Your reference: SSD 6882
Our reference: EF13/5564; DOC15/10470-17
Contact: Jason Price 6969 0700

Re ProTen poultry production complex at Euroley – additional information requested

As foreshadowed to your Thomas Piovesan the EPA has reviewed the information provided and determined that we require additional information to clarify the potential air quality impacts of the proposed development. This additional information is detailed in Attachment 'A'. We have discussed this request for additional information with the applicant and provided a draft copy of Attachment 'A'.

Figure 6.1 Predicted 1-second peak to mean concentration

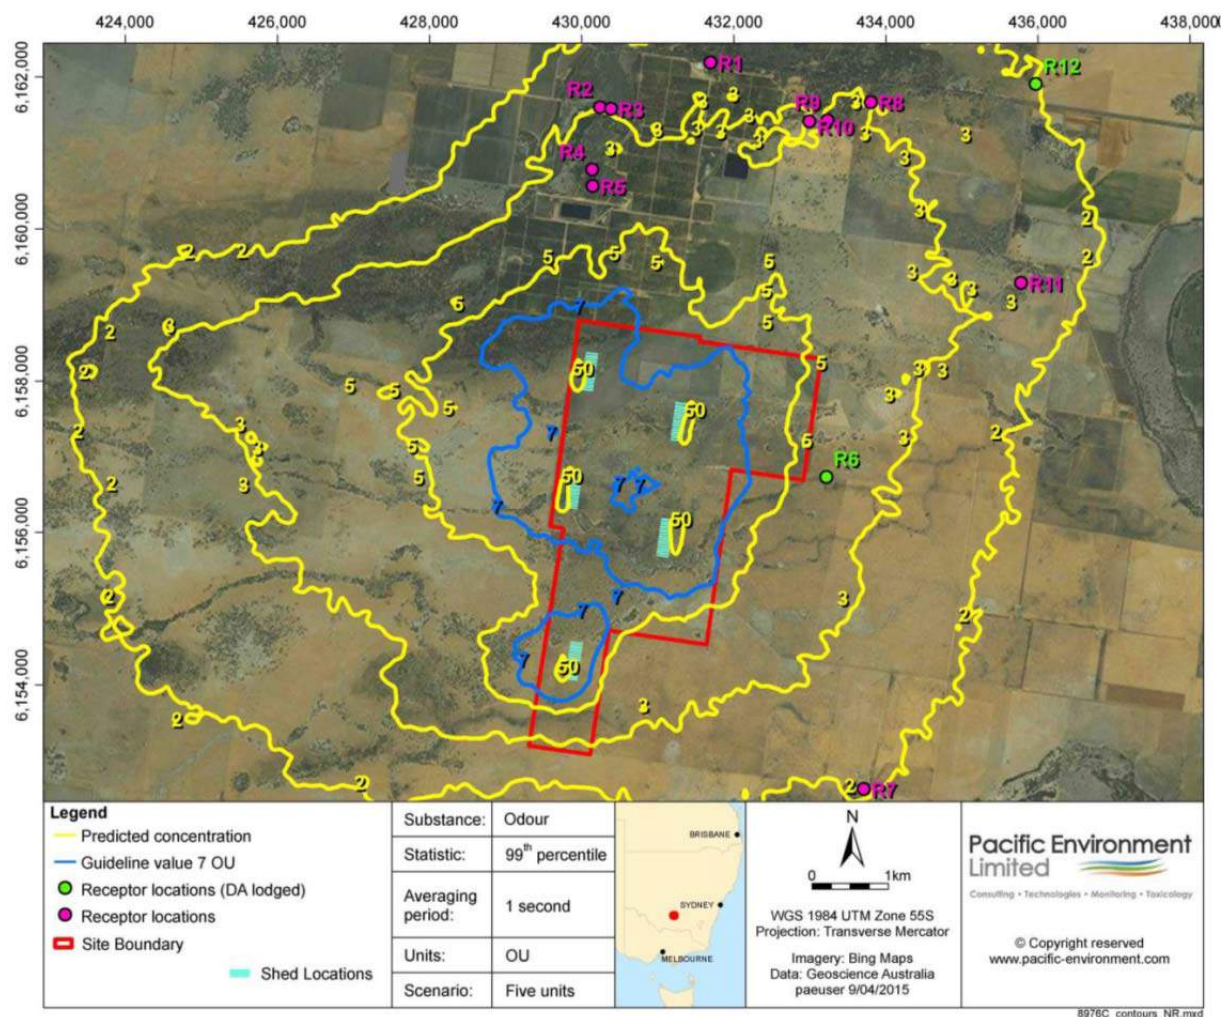
8. Project odour criterion should be 5 Odour Units (OU)

An odour criterion of 7OU was assumed for the project. PEL (2015) acknowledge there are 13 receptors located within 5 kilometres of the site. These 13 private sensitive receptors are the community affected by this project. Assuming approximately 2.8 persons per household results in an affected population of 36 people. Using equation 7.2 in the *Approved Methods for the Modelling and Assessment of Air Pollutants in NSW*, the odour performance criterion for project is 5 OU.

The EPA considers an appropriate odour performance criterion for the project is 5 OU. The EPA notes the project, as modelled in PEL (2015) marginally complies with an odour performance criterion of 5 OU. This highlights the need for the proponent to consider feasible odour mitigation measures that will be applied should odour impacts occur once operational (see issue 10).

Figure 6.2 Predicted maximum 24-hour PM₁₀ concentration

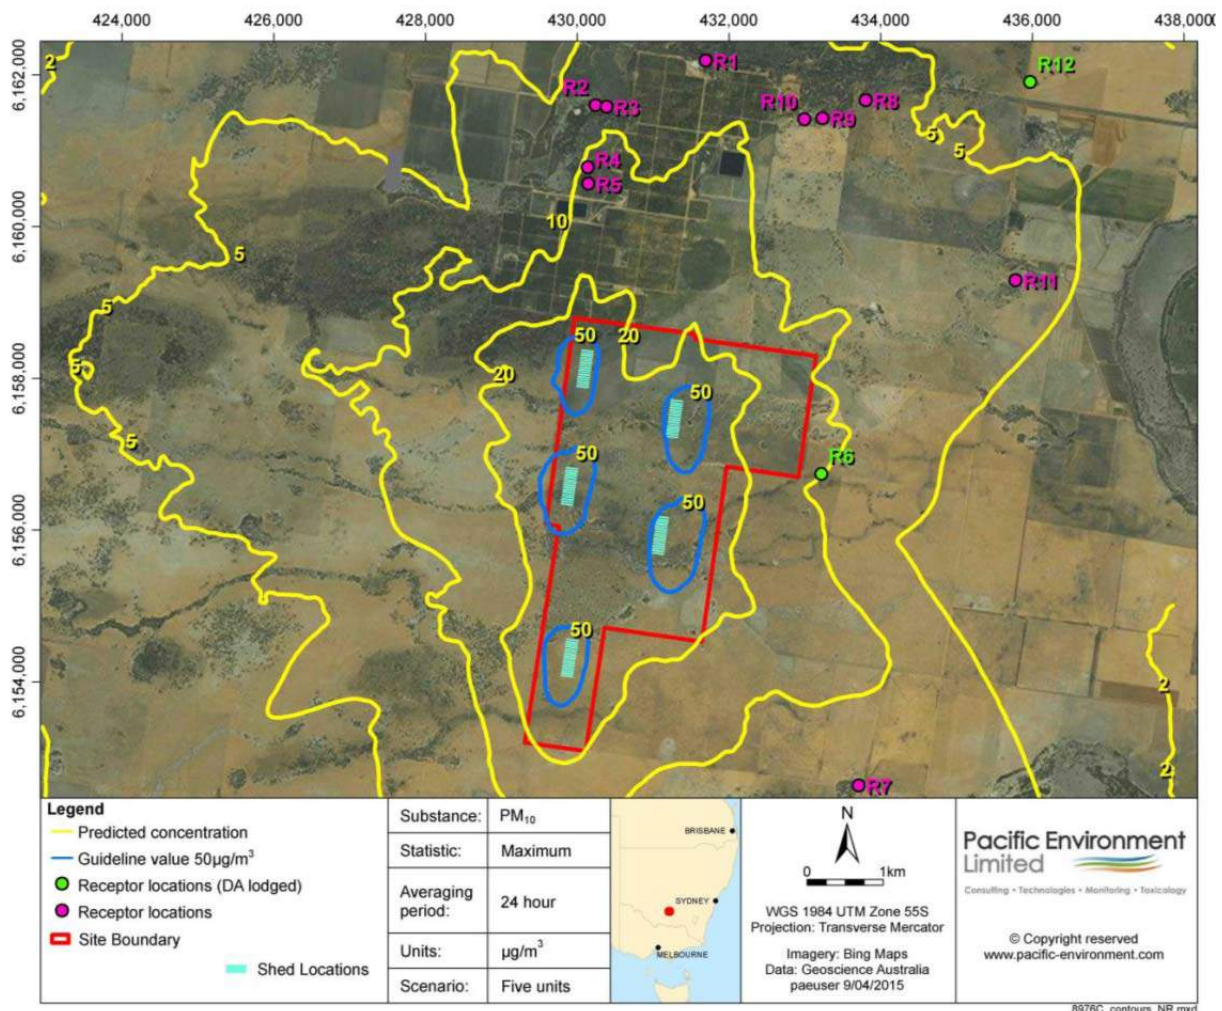
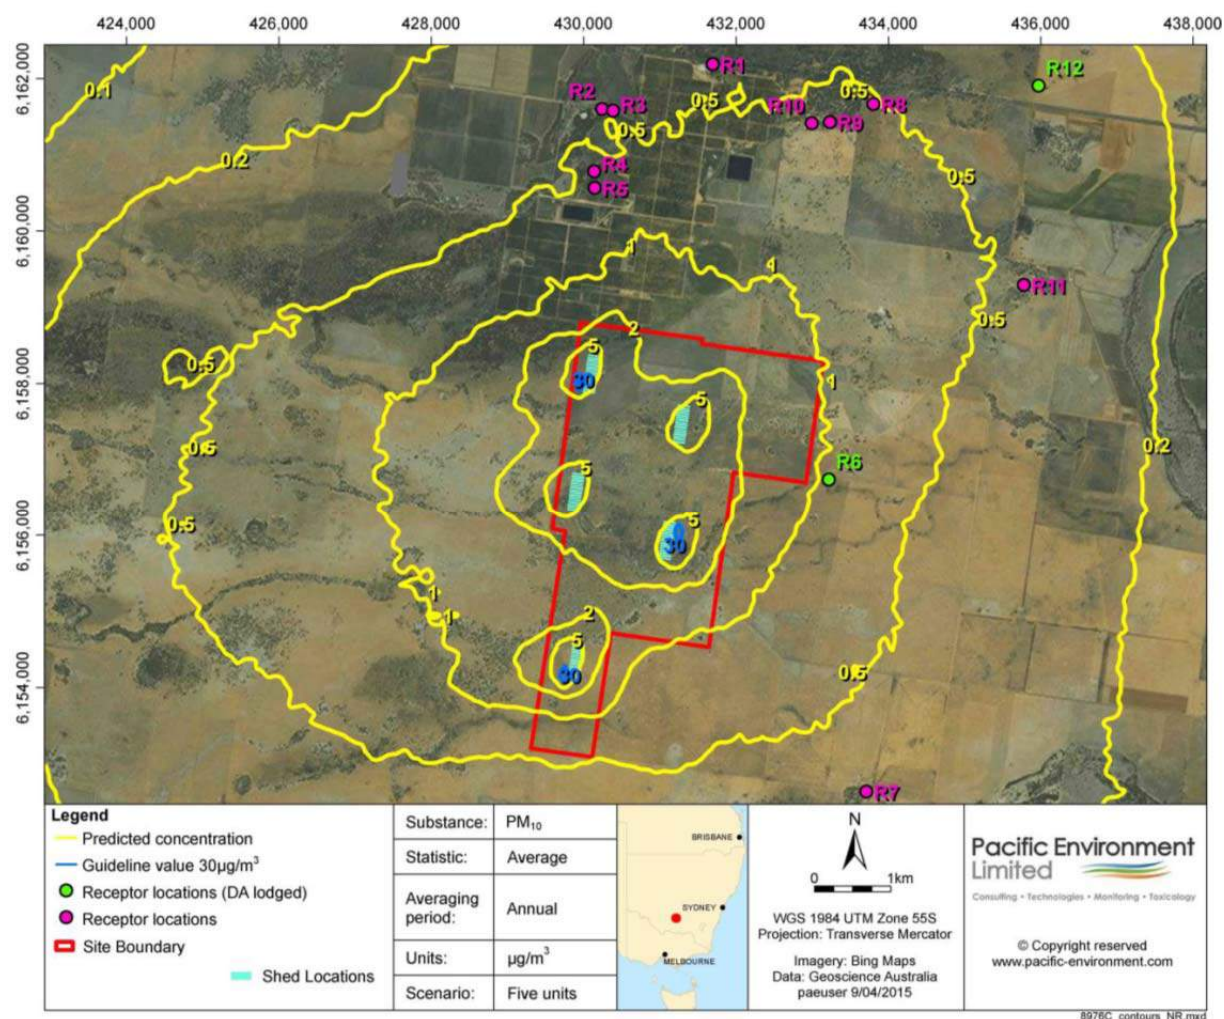
9. Assessment of cumulative particulate impacts not in accordance with the Approved Methods

Cumulative 24 hour average PM₁₀ has been assessed using a statistical approach (Monte Carlo Simulation), focusing on the nearest sensitive receptors to the development. The Monte Carlo simulation is not listed as a methodology to incorporate background concentrations in the *Approved Methods for the Modelling and Assessment of Air Pollutants in NSW*.

The EPA requests a revision of the cumulative assessment of 24 hour average PM₁₀ concentrations in accordance with the methodologies listed in the Approved Methods for the Modelling and Assessment of Air Pollutants in NSW or provide detailed justification for adopting an alternate method.
